# ETHOS URBAN

## Response to Public Individual Submissions

Redevelopment of Greenwich Hospital

27 September 2019 | 2190376

SHADOW DIAGRAMS

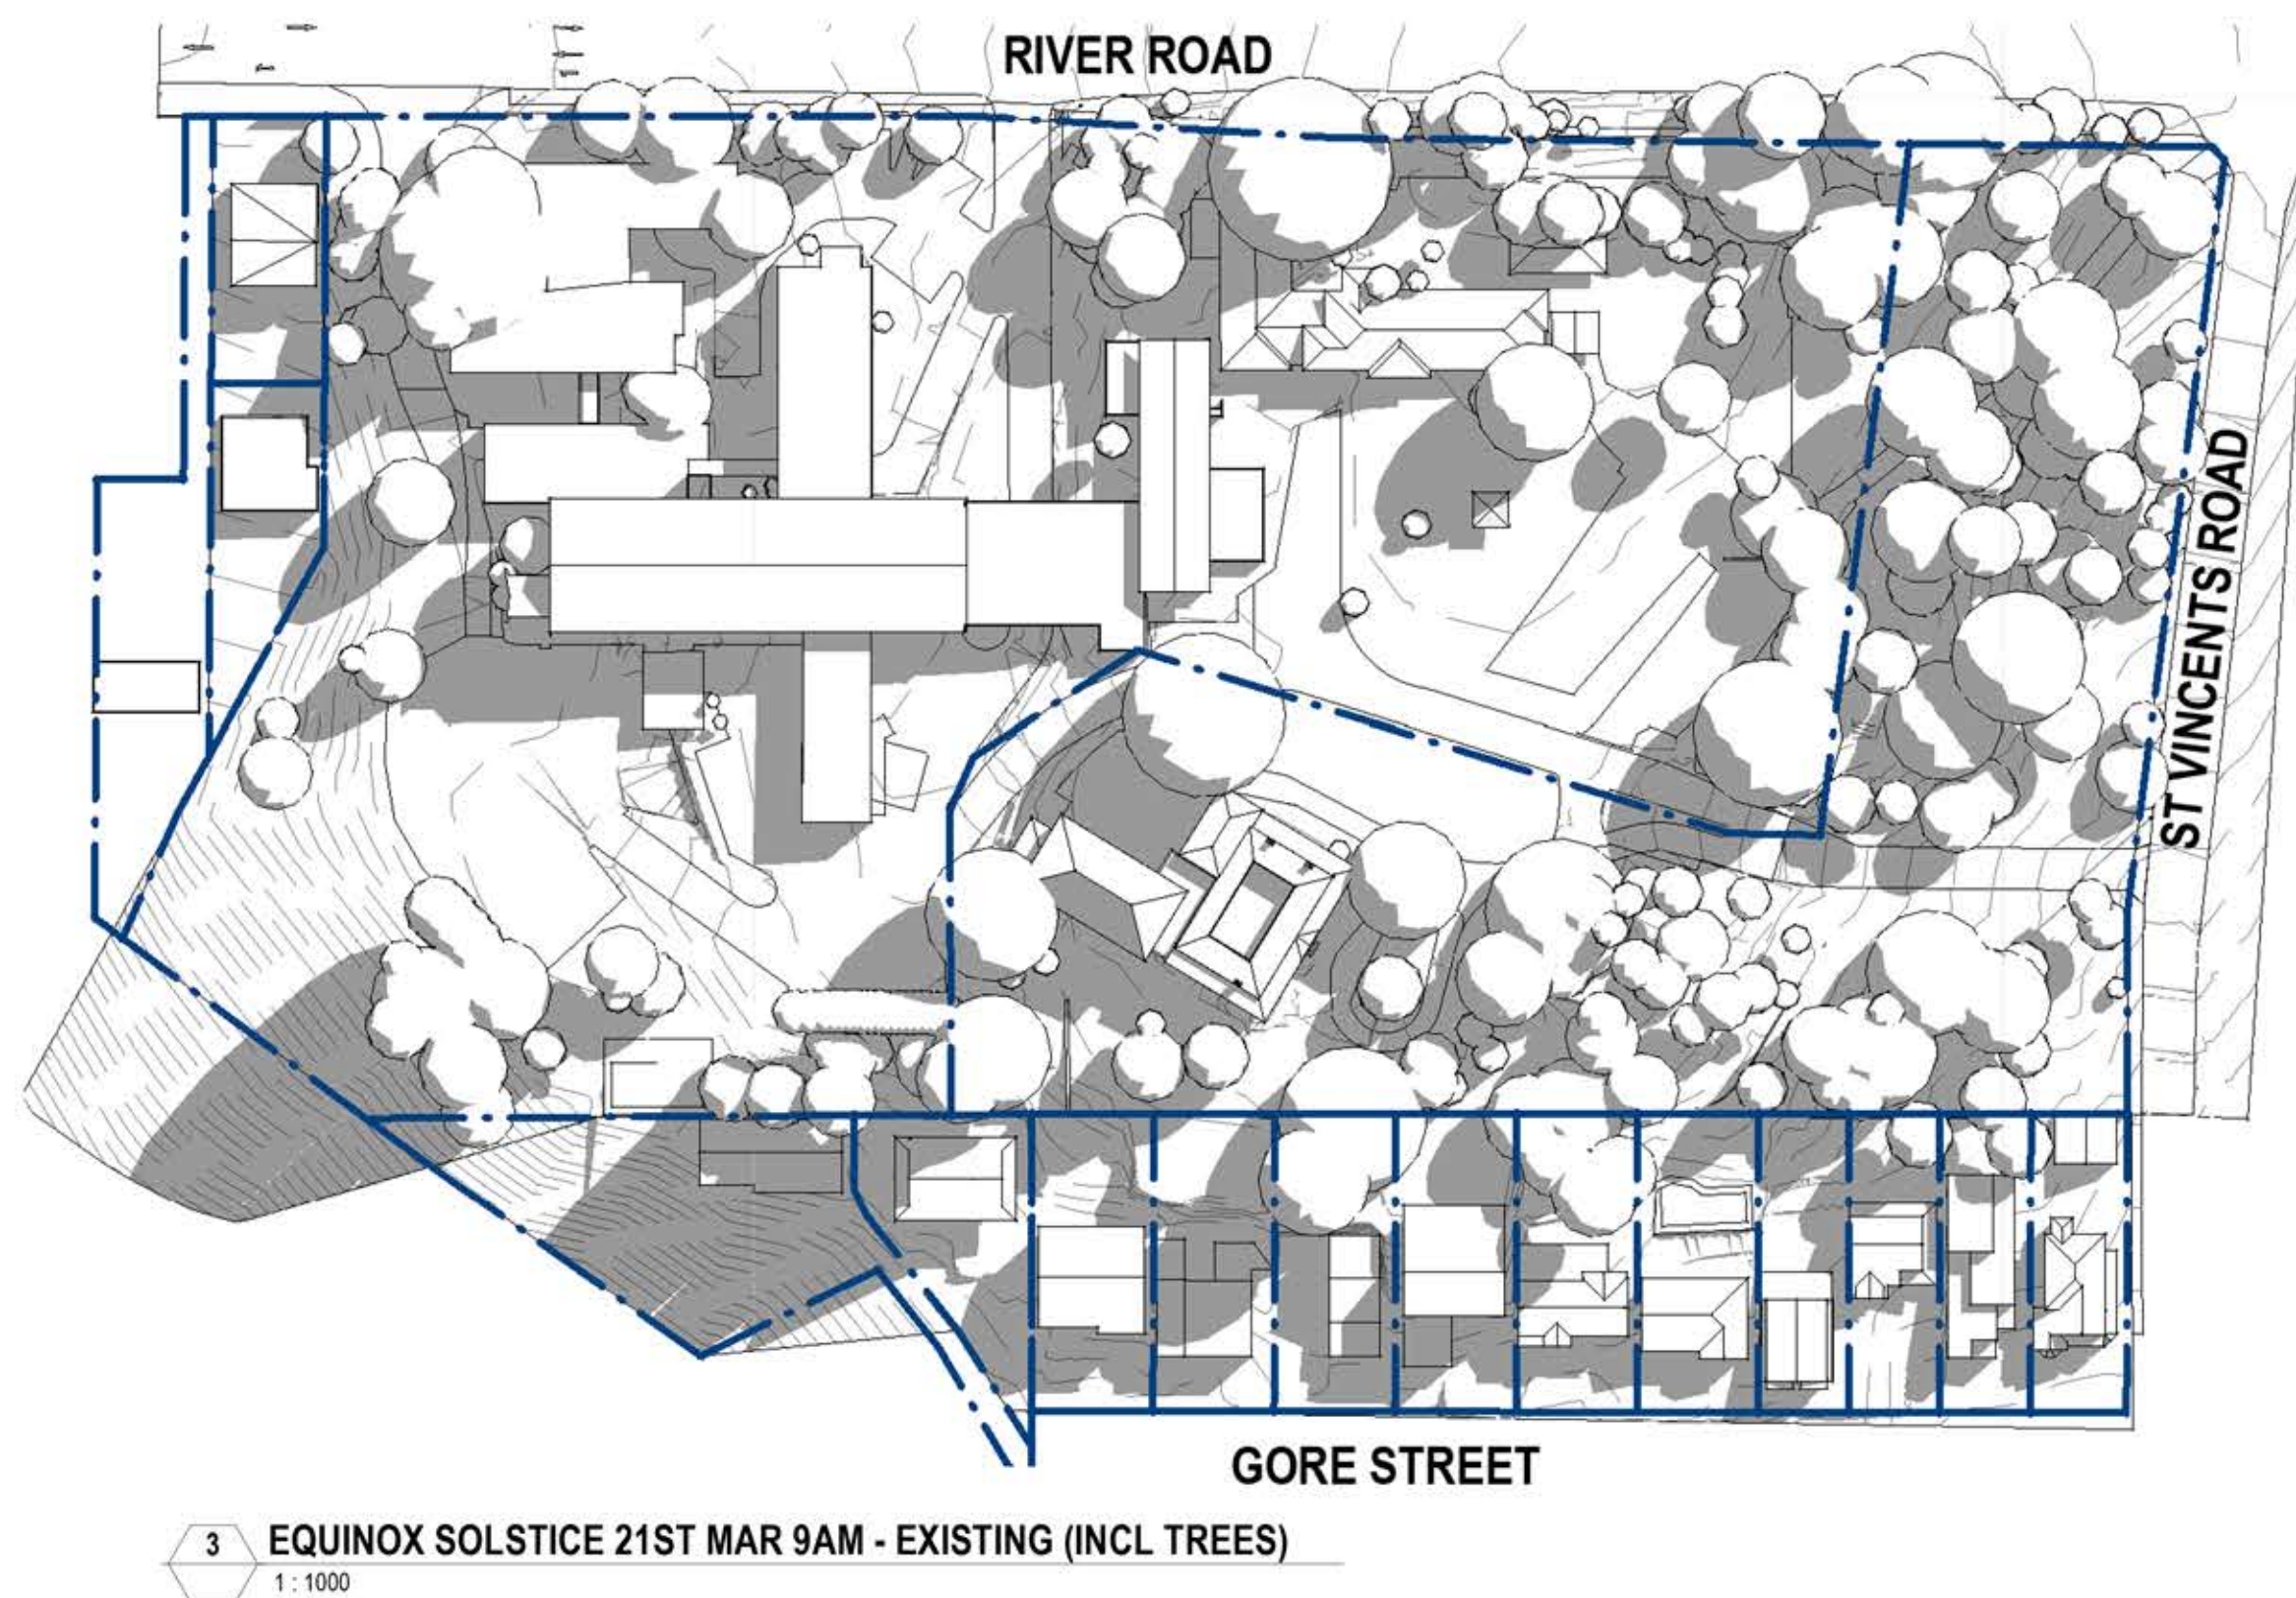
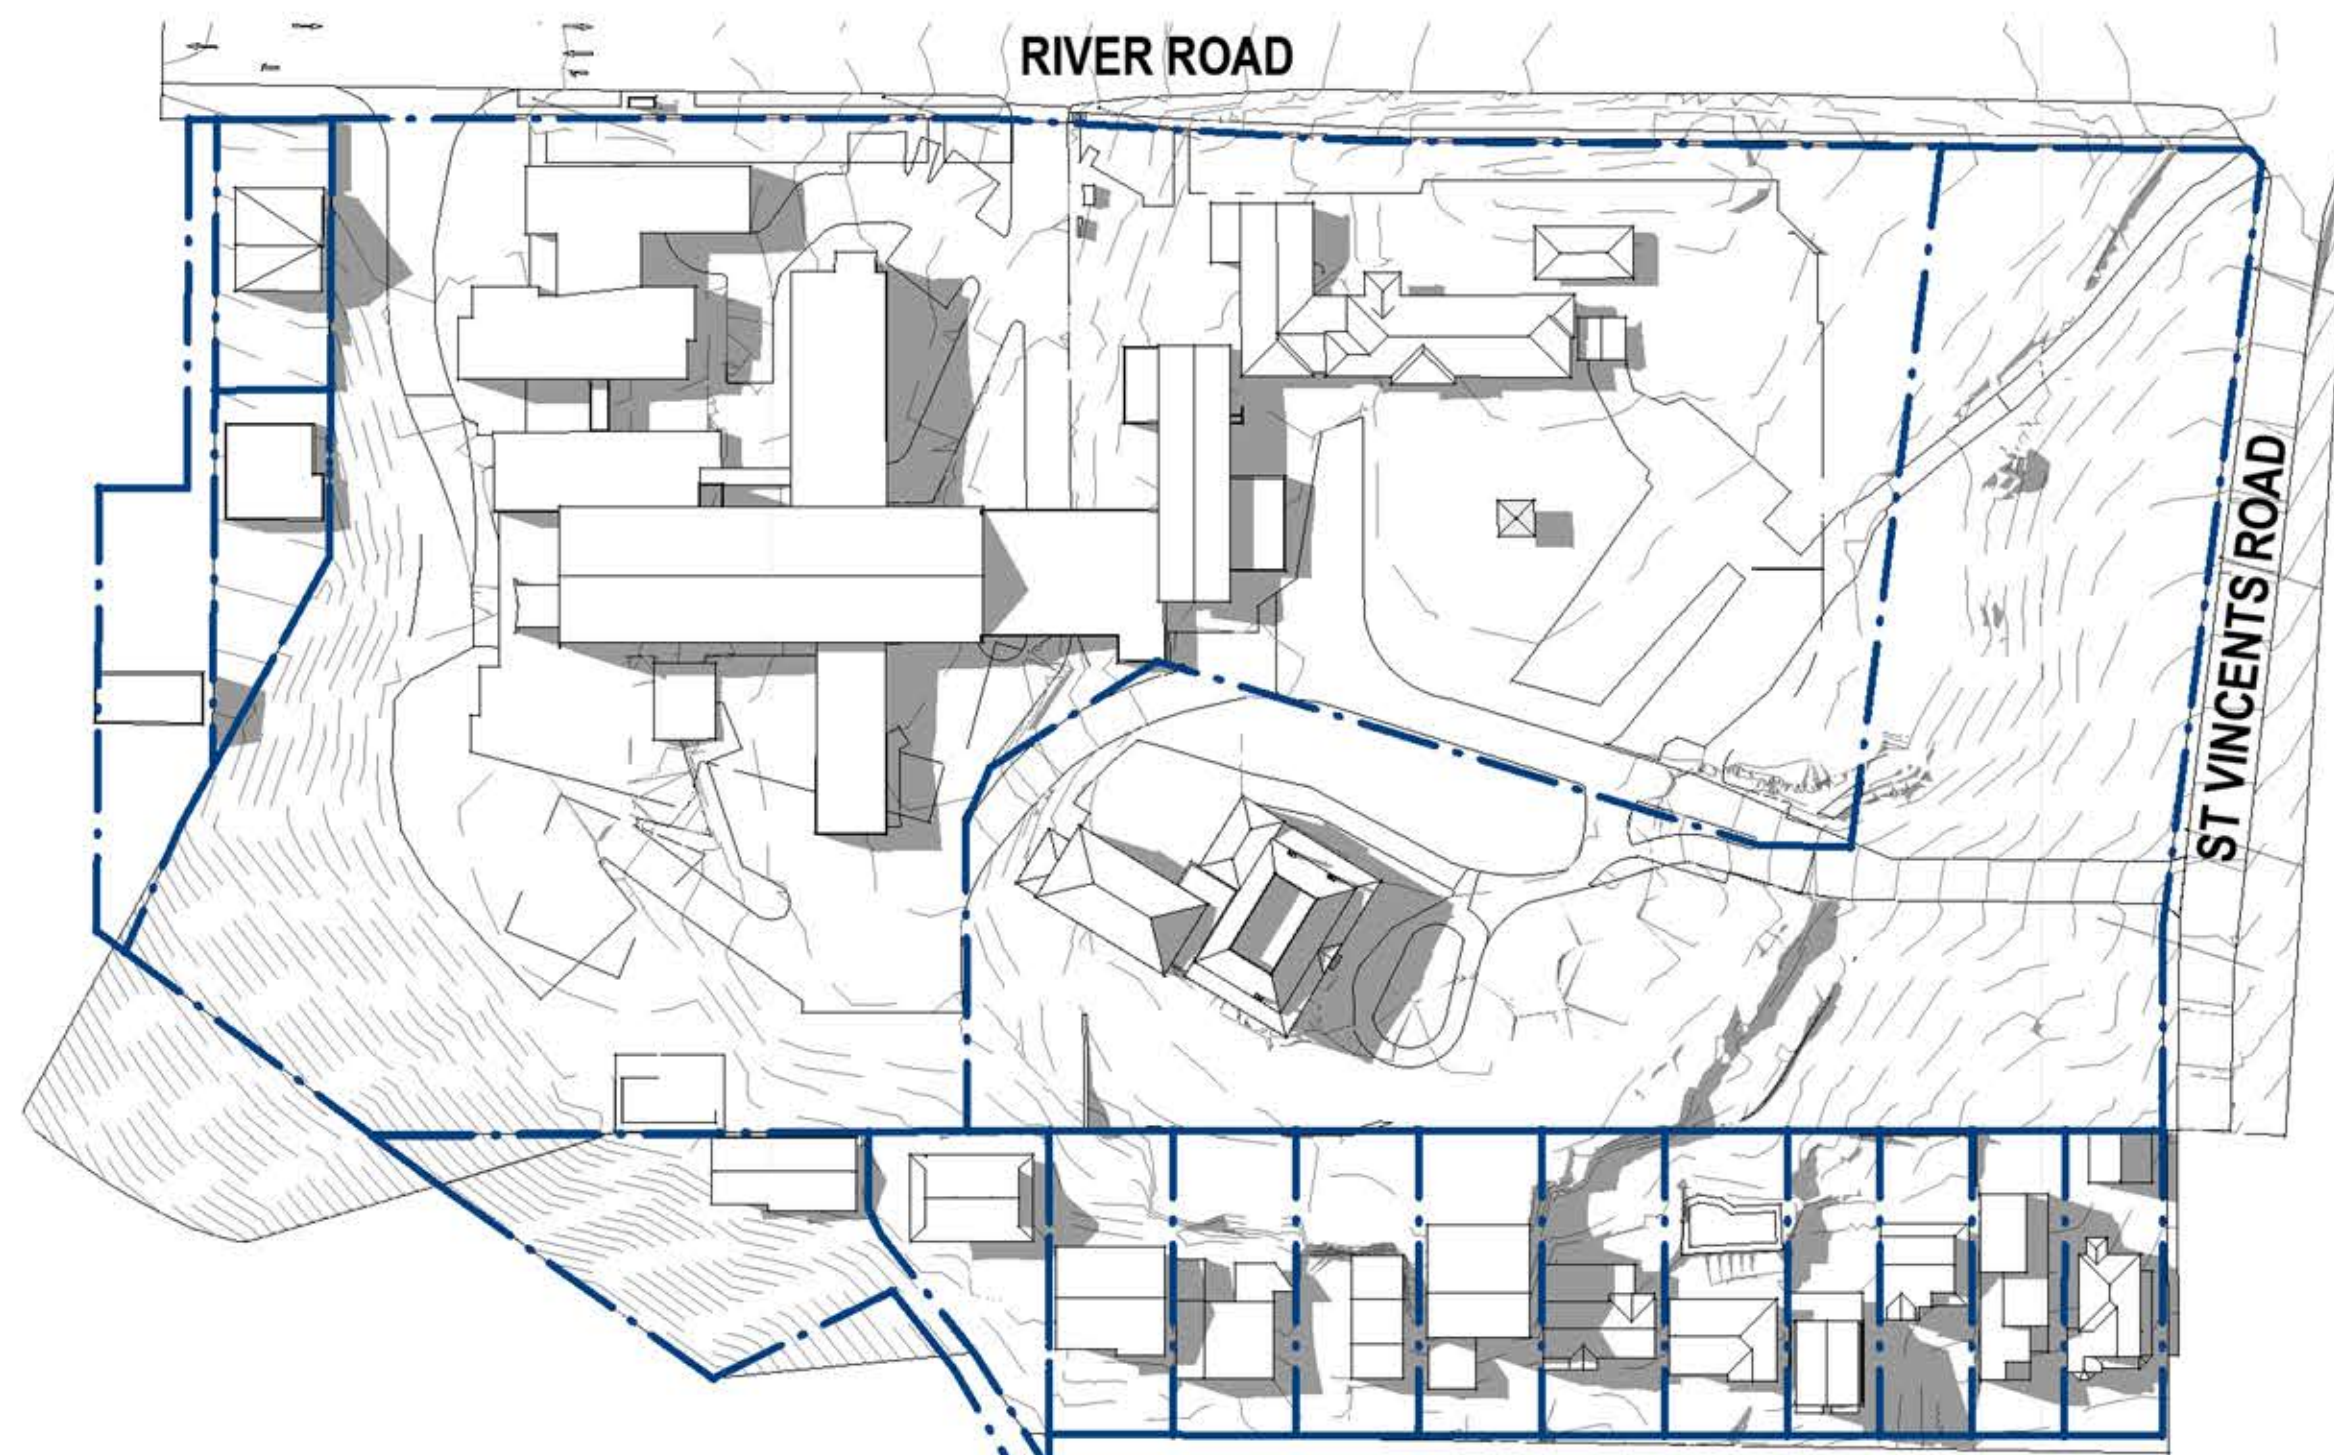
<b>Overshadowing</b>		
The development will result in excessive overshadowing	Shadow diagrams have been supplied as part of the Amended Architectural Plans prepared by Bickerton Masters at <b>Appendix A</b> of the RTS, demonstrating that only minimal overshadowing will be generated by the proposed redevelopment outside of the site.	12
Overshadowing onto Bob Campbell Oval	Shadow diagrams have been supplied as part of the Amended Architectural Plans prepared by Bickerton Masters at <b>Appendix A</b> of the RTS, demonstrating that no overshadowing will occur onto Bob Campbell Oval.	11
Overshadowing onto Gore Creek Bushland Reserve	Shadow diagrams have been supplied as part of the Amended Architectural Plans prepared by Bickerton Masters at <b>Appendix A</b> of the RTS, demonstrating that no overshadowing will occur onto Gore Creek Bushland Reserve.	7
<b>Traffic and Parking</b>		
Insufficient parking has been proposed	A Traffic and Parking Impact Assessment was submitted with the original application which concludes the proposed provision of parking is appropriate. Parking for the seniors living component complies fully with the rates stipulated in SEPP Seniors, with one space per unit plus additional visitor spaces; 163 parking spaces are proposed for the hospital to service the 150 beds/rooms. Public transport options are also available for the site, meaning a proportion of visitors will not elect to drive.	15
